Andrew Kelly  
Project Manager  
M54M6 Project Team  
Highways England  
2 Colmore Square  
Birmingham  
B4 6BN

17 December 2020

**M54 TO M6 LINK ROAD SCHEME ("THE SCHEME")  
PINS REF: TR010054  
APPLICATION TO CORRECT SHEET 6 OF THE LAND PLANS (DOCUMENT  
REFERENCE AS-065)**

Drawing Number HE514465	Originator -GHX	Volume -LLO	Rev P08
Location Z2_SW_PR_Z	Type -DR-LR-1005	Role -DR-LR-1005	Number P08

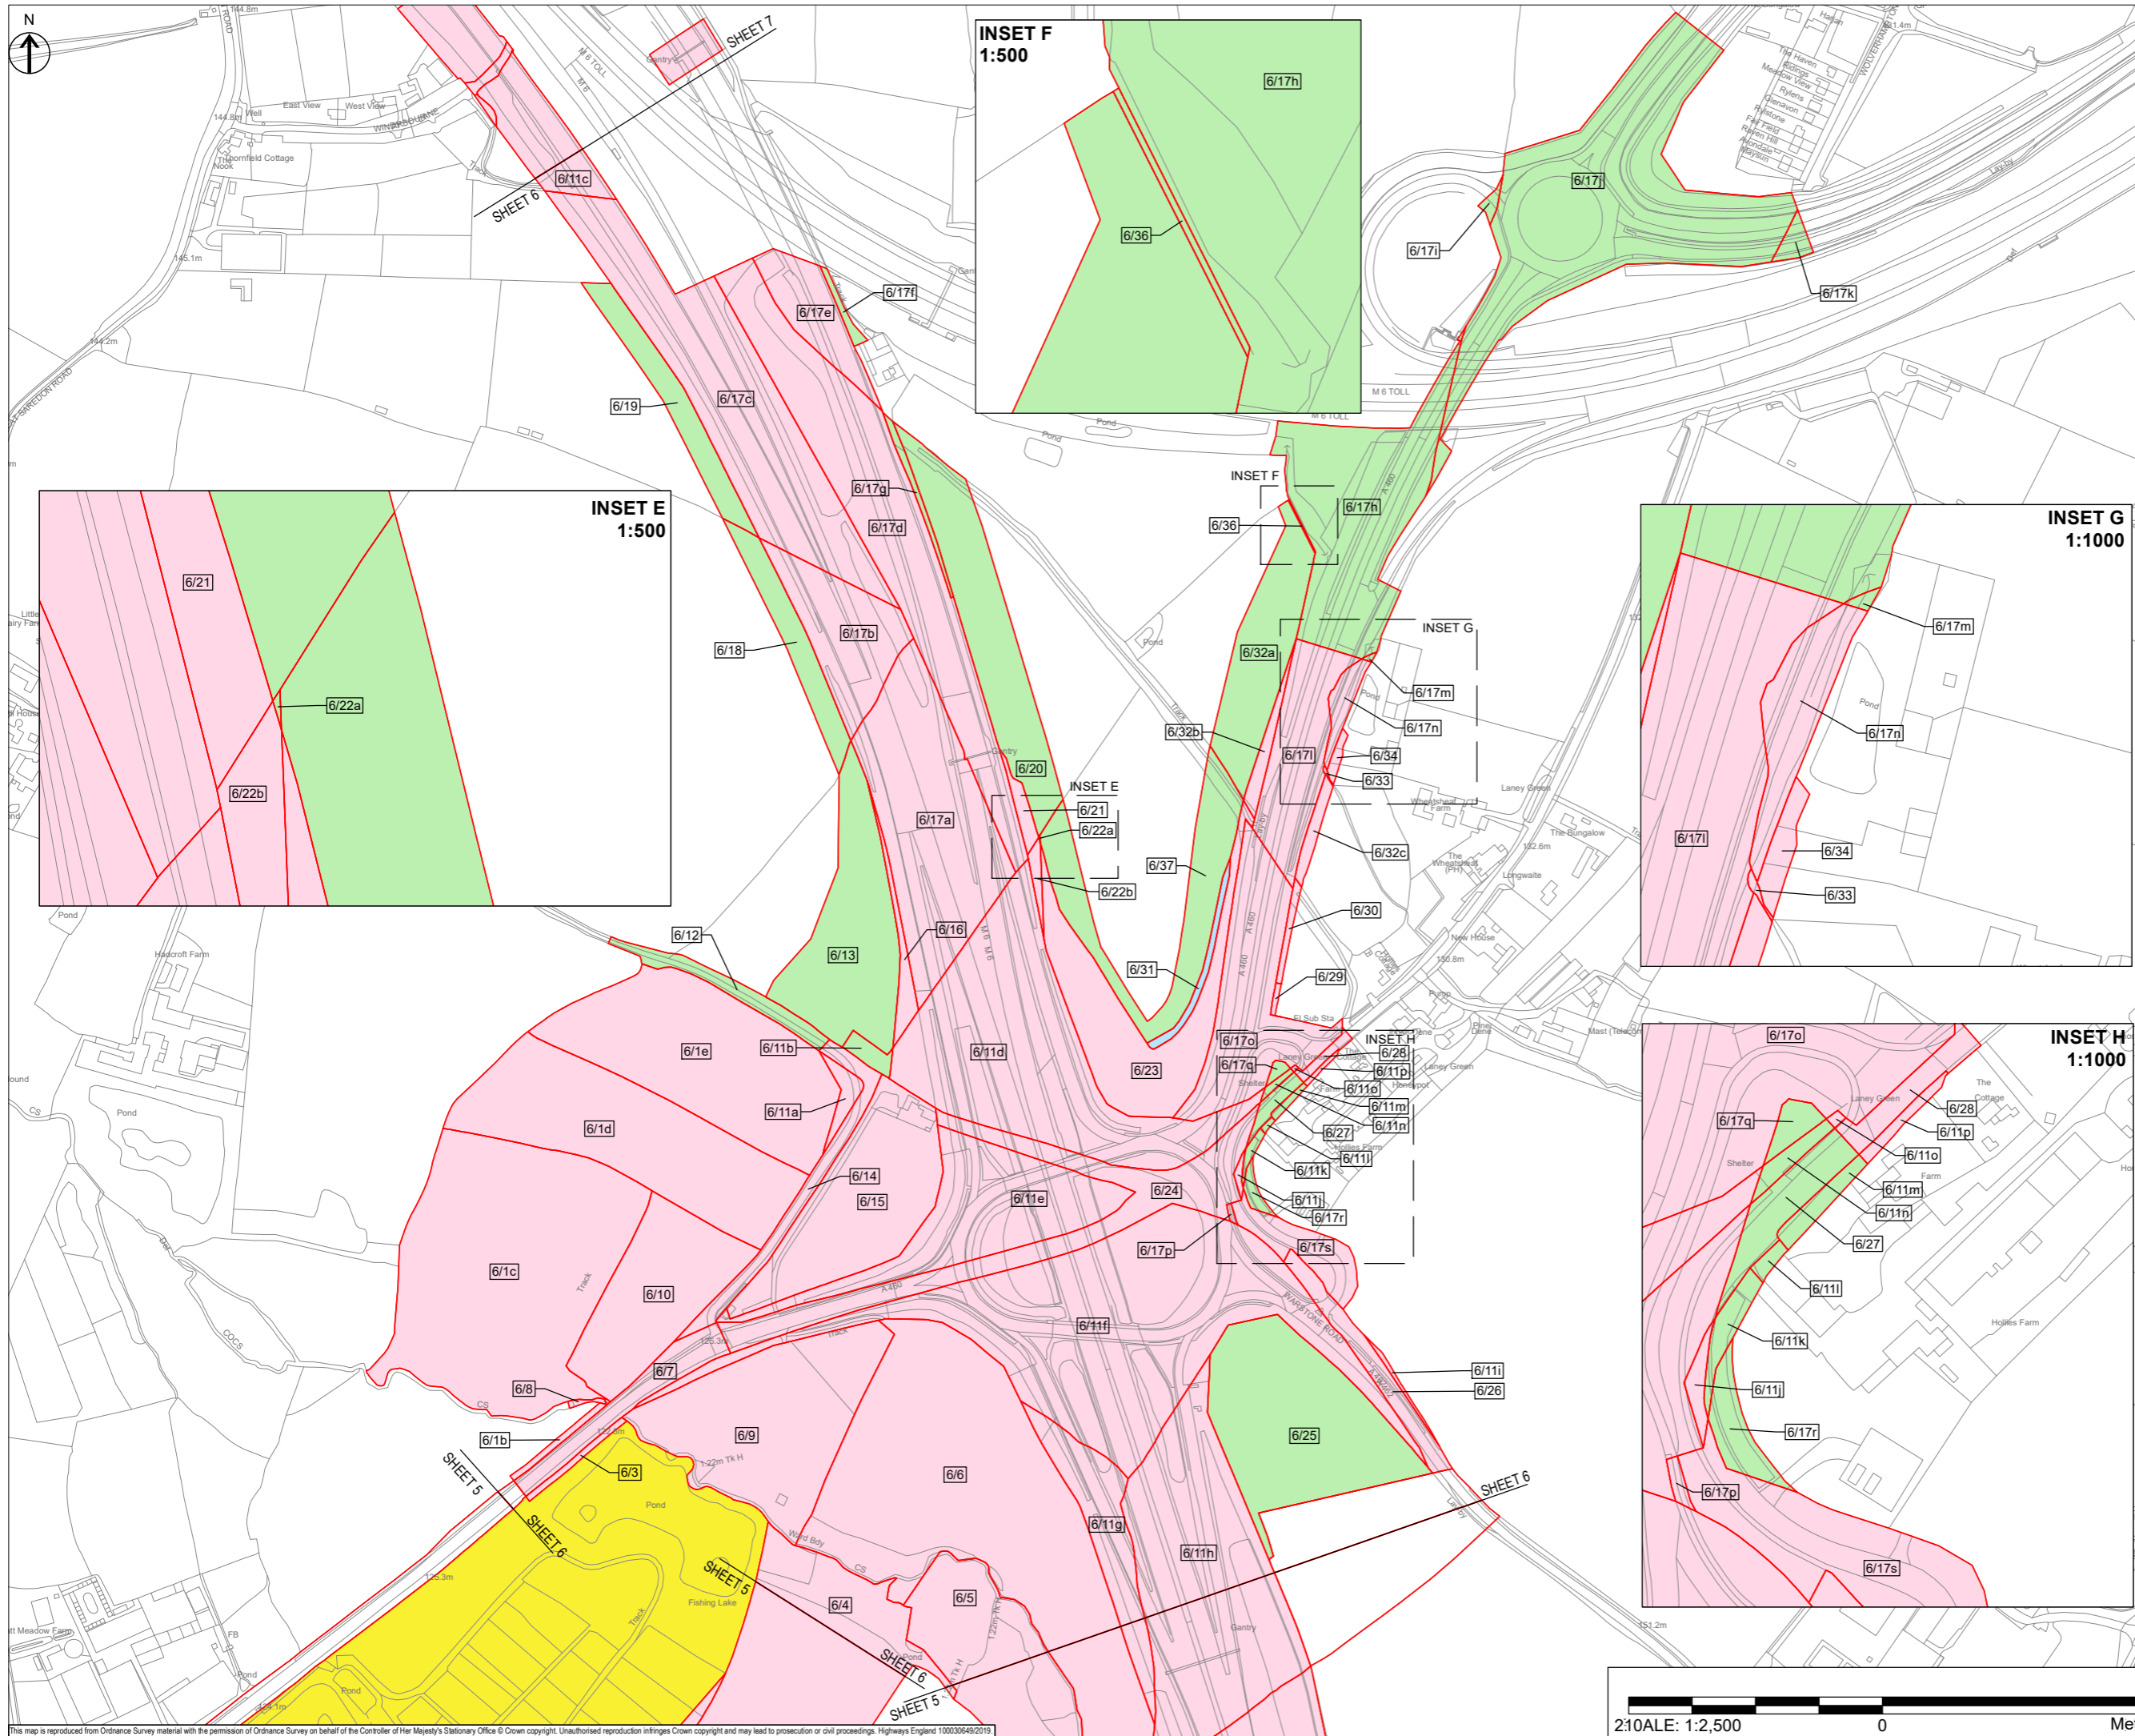
At the compulsory acquisition hearing held on Thursday 10 December 2020, the Examining Authority was advised of an error on sheet 6<sup>1</sup> of the Land Plans. The purpose of this letter is to formally request an amendment to that plan.

<sup>1</sup> Sheet 5 of the Land Plans also displays plot 6/25 and 6/38 beyond the cut lines and has been updated for completeness.

The Land Plans document with corrected sheet 6 is enclosed which shows a reduced Plot 6/25 as temporary possession for construction purposes and a new Plot 6/38 as permanent acquisition for the Junction Works. As indicated above, Sheet 5 of the Land Plans also displays plot 6/25 and 6/38 beyond the cut lines and has been updated for completeness. We confirm that all other plans are accurate and no other changes or corrections to the DCO plans are necessary.

1. Guide to the Application updating the version numbers for the documents below (tracked and clean versions).
2. Revised Land Plans showing the new plot 6/38 and revised plot 6/25 boundary.
3. Revised Book of Reference (tracked and clean versions).
4. Revised Statement of Reasons (tracked and clean versions).
5. Plan showing the General Arrangement for the Scheme overlaid on the revised Land Plans to illustrate why the 'additional land' is required.
